Our ref: Newington College Redevelopment (Concept and Stage 1) (SSD-78268465)

Subject: Response to Submissions

I refer to the State Significant development application for the Newington College Redevelopment (Concept and Stage 1) (SSD-78268465) and the Department's Response to Submissions (RtS) letter dated 15 July 2026.

ATTACHMENT 1 KEY ISSUES / FURTHER INFORMATION REQUIRED

Proposed footbridge over Stanmore Road

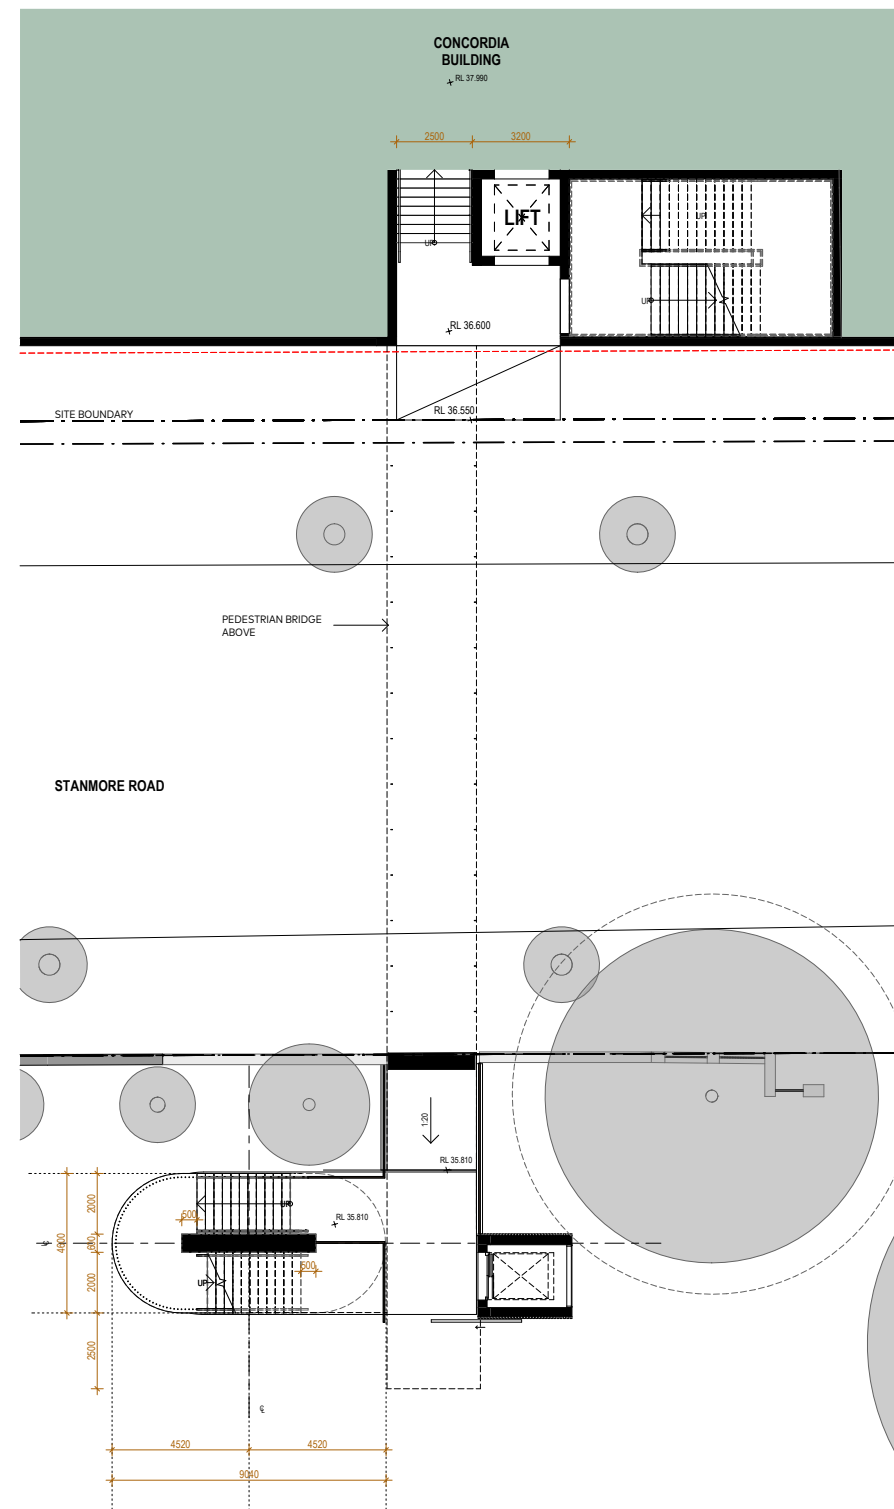
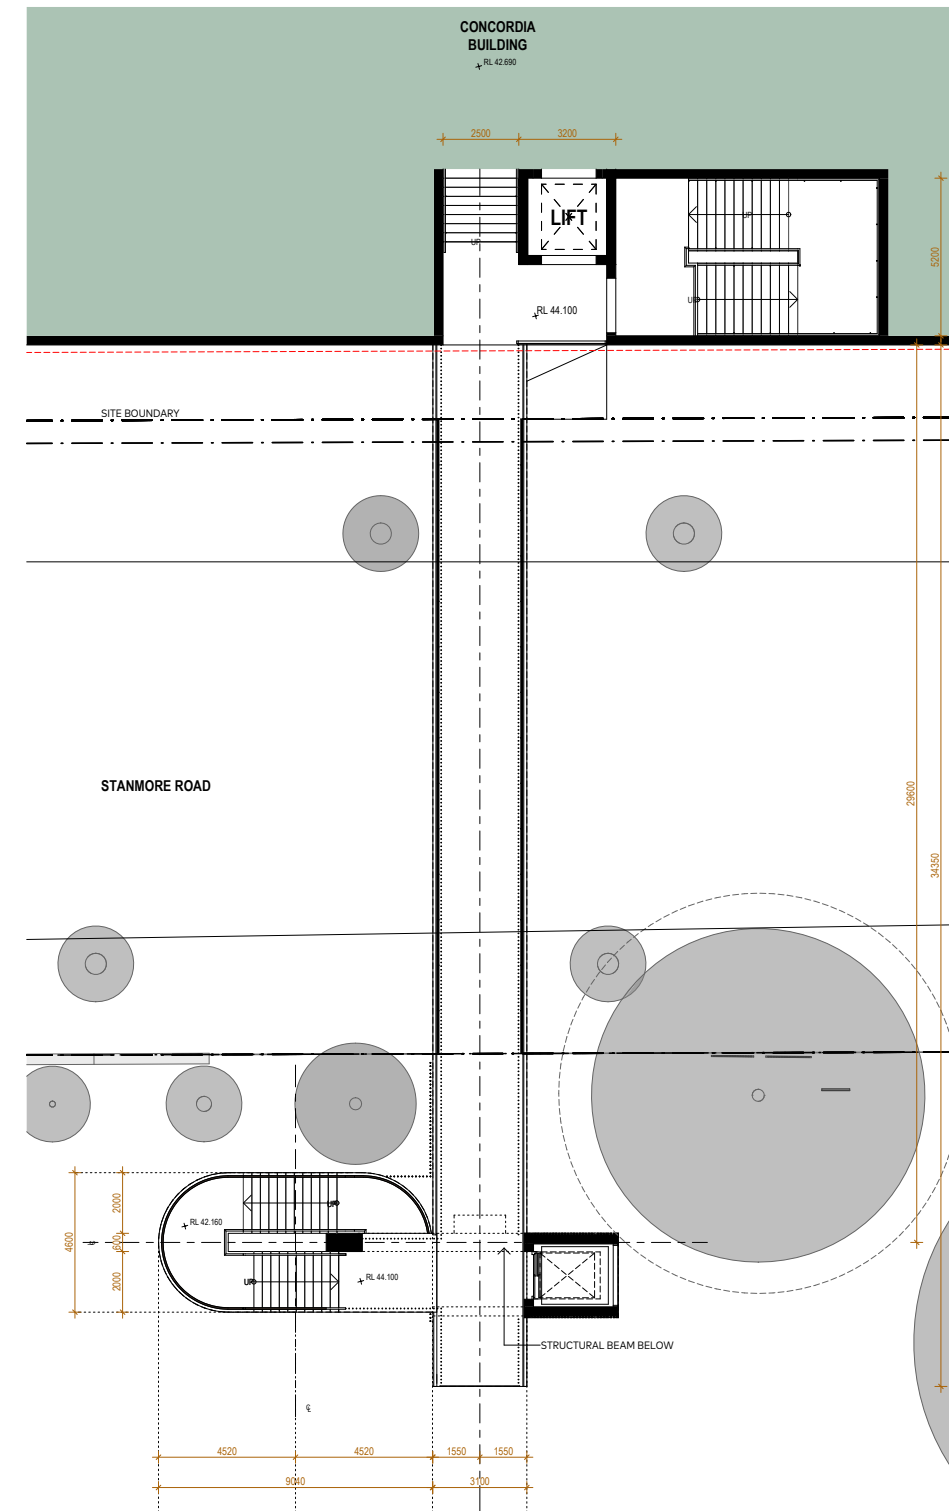
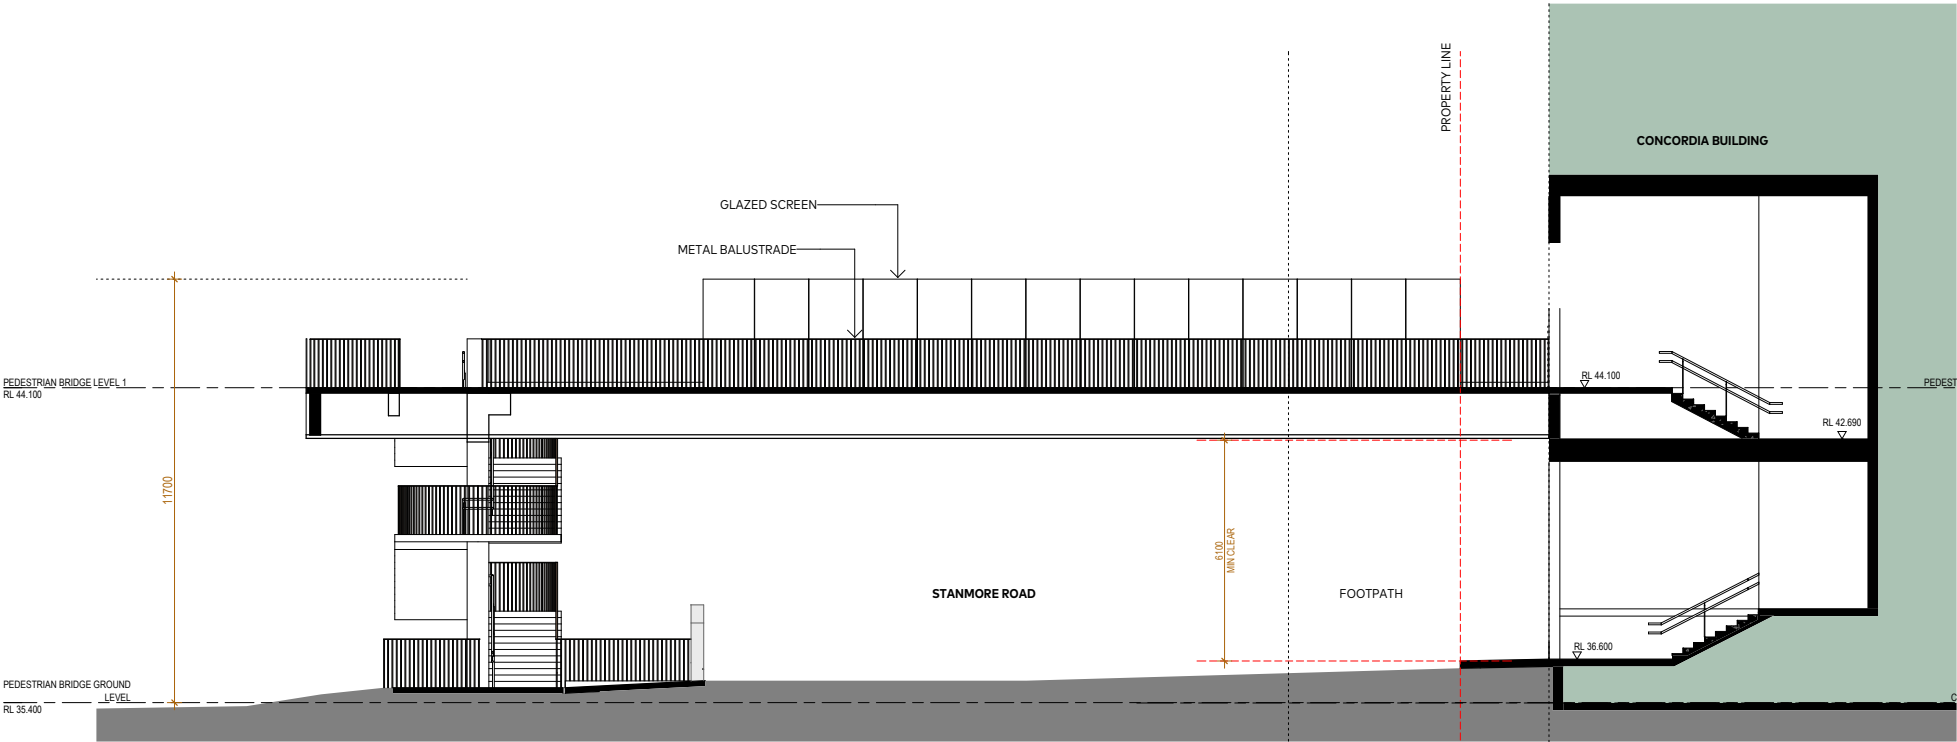
- As currently presented, the proposed pedestrian footbridge reads primarily as infrastructure associated with the College rather than an integrated component of the public domain. To ensure that the footbridge functions as an integrated part of the public pedestrian network, further design development and justification are required demonstrating:

- the intended public accessibility of the bridge
 - how pedestrian approaching from either side of Stanmore Road will identify and access the bridge
 - how the lift, stair and landscaping structures contribute positively to the public domain and supports broader pedestrian movement outcomes beyond the College

- Provide a pedestrian circulation plan demonstrating public access routes and pedestrian movements between the bridge and surrounding footpath network. Indicate the RL, setbacks and dimensions of the bridge on the architectural drawings.

Temporary Carpark

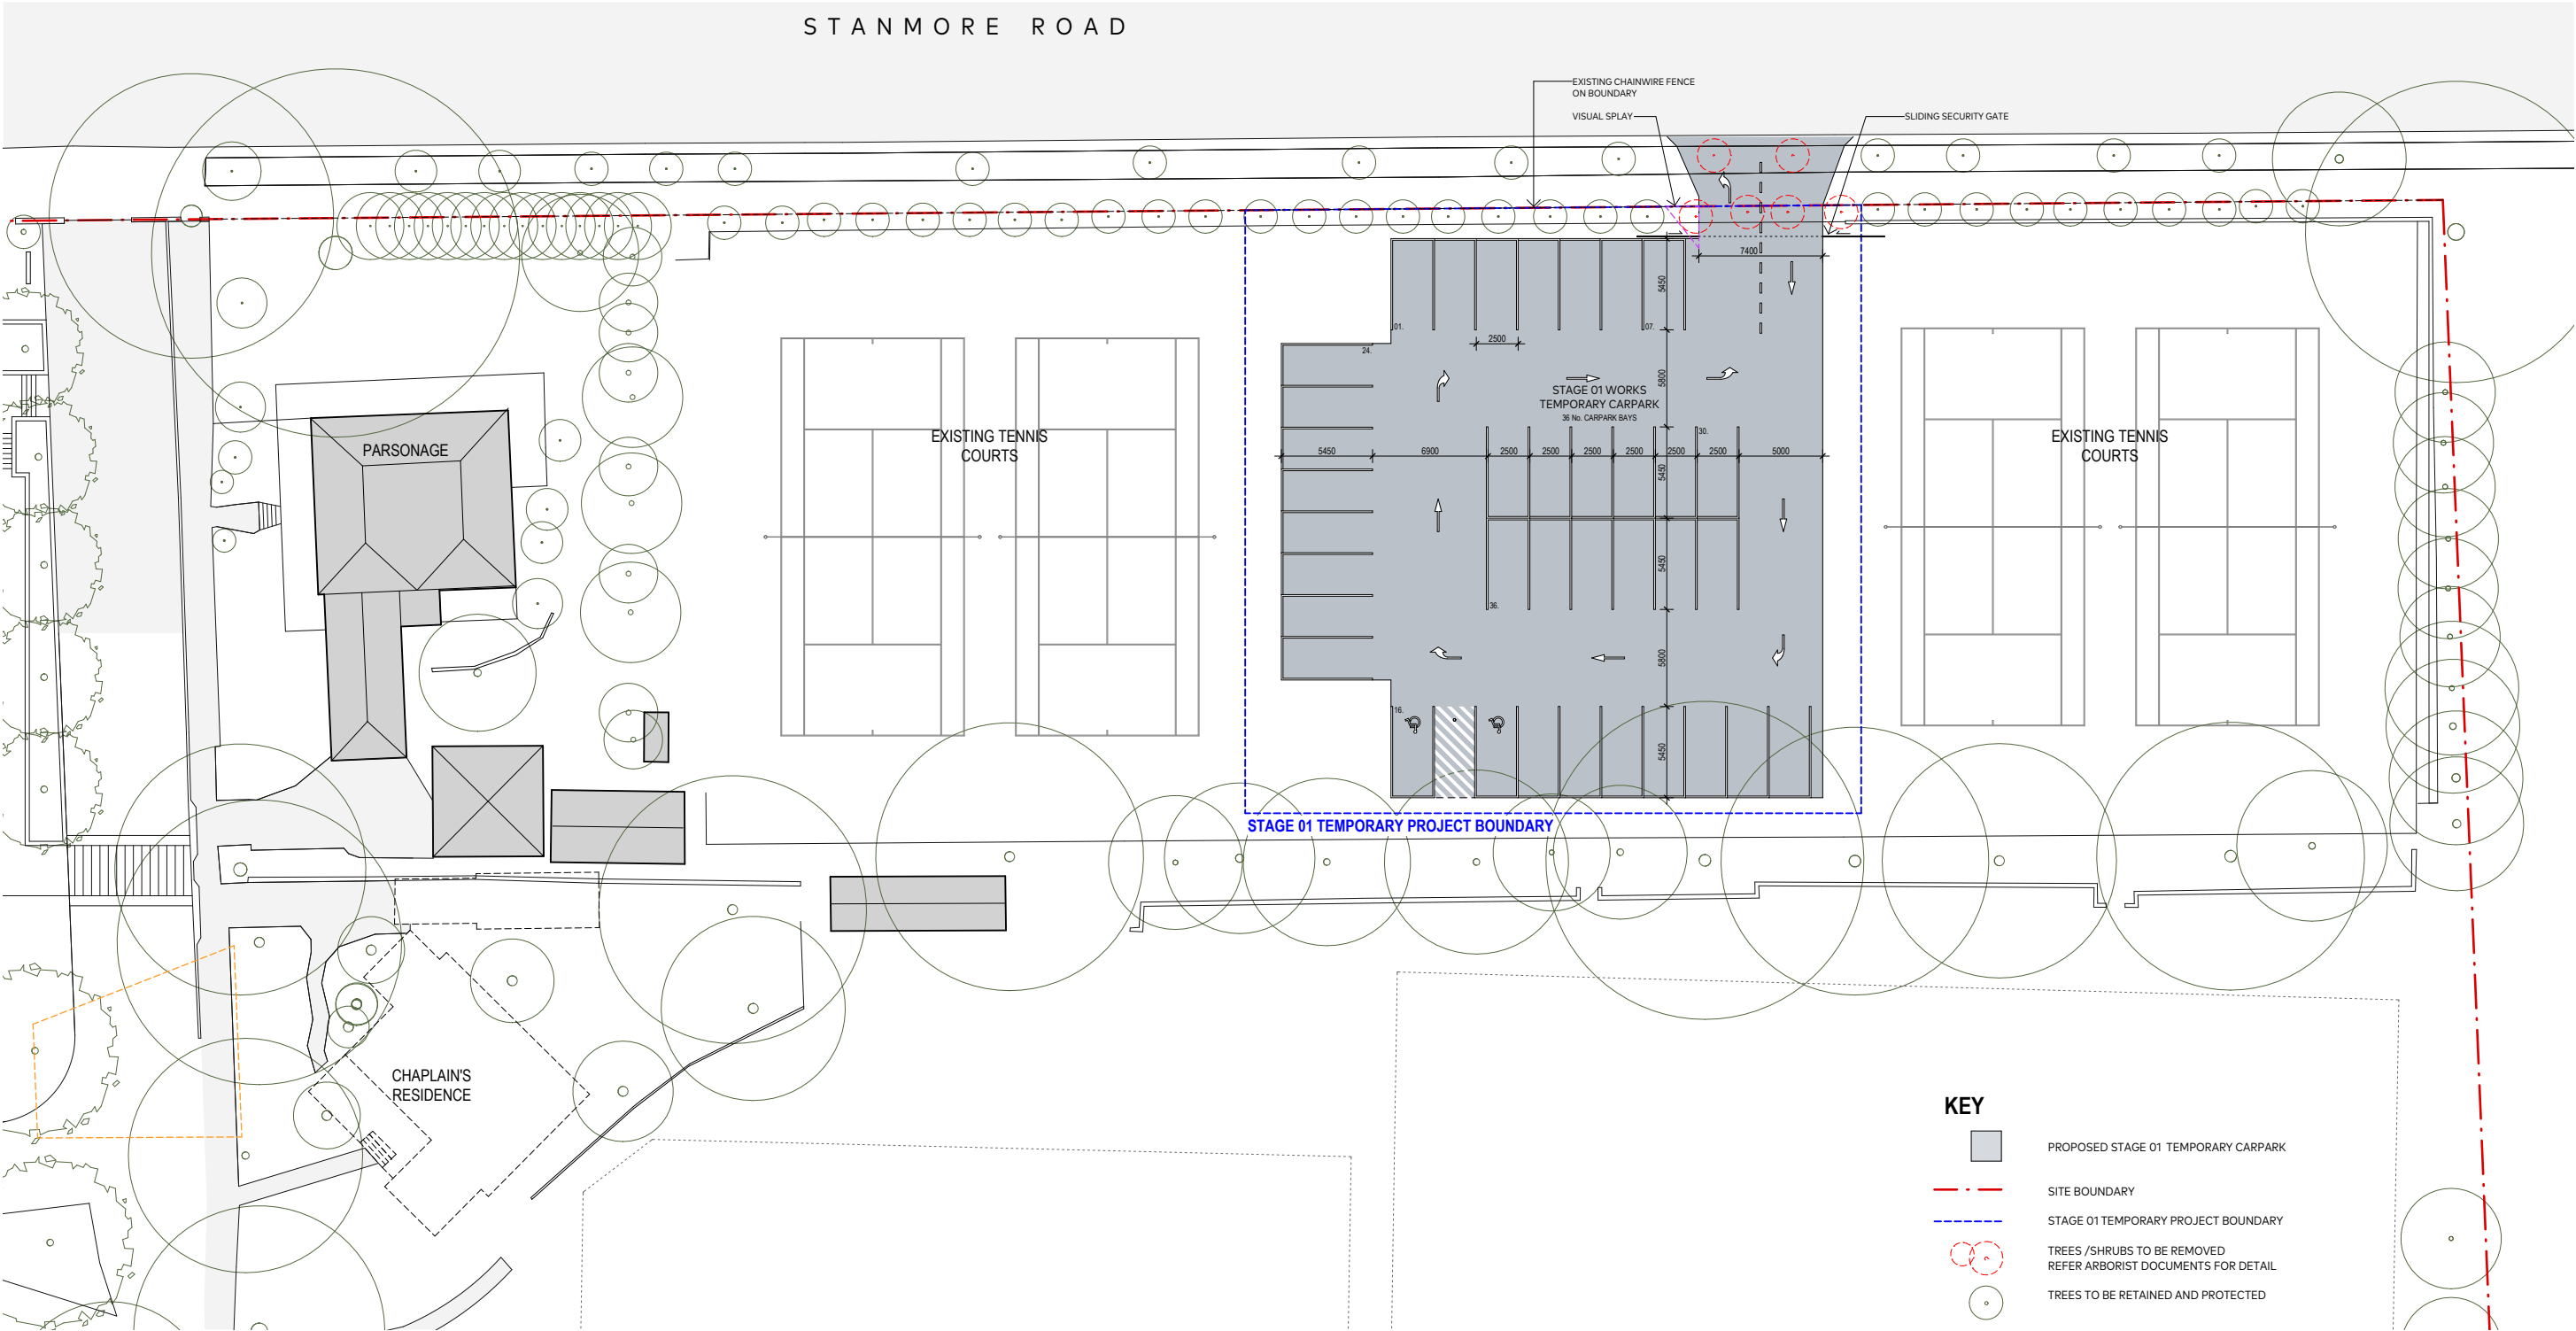
- Provide landscape plans demonstrating the reinstatement of the tennis courts, landscaping and associated works following the decommissioning of the temporary carpark.
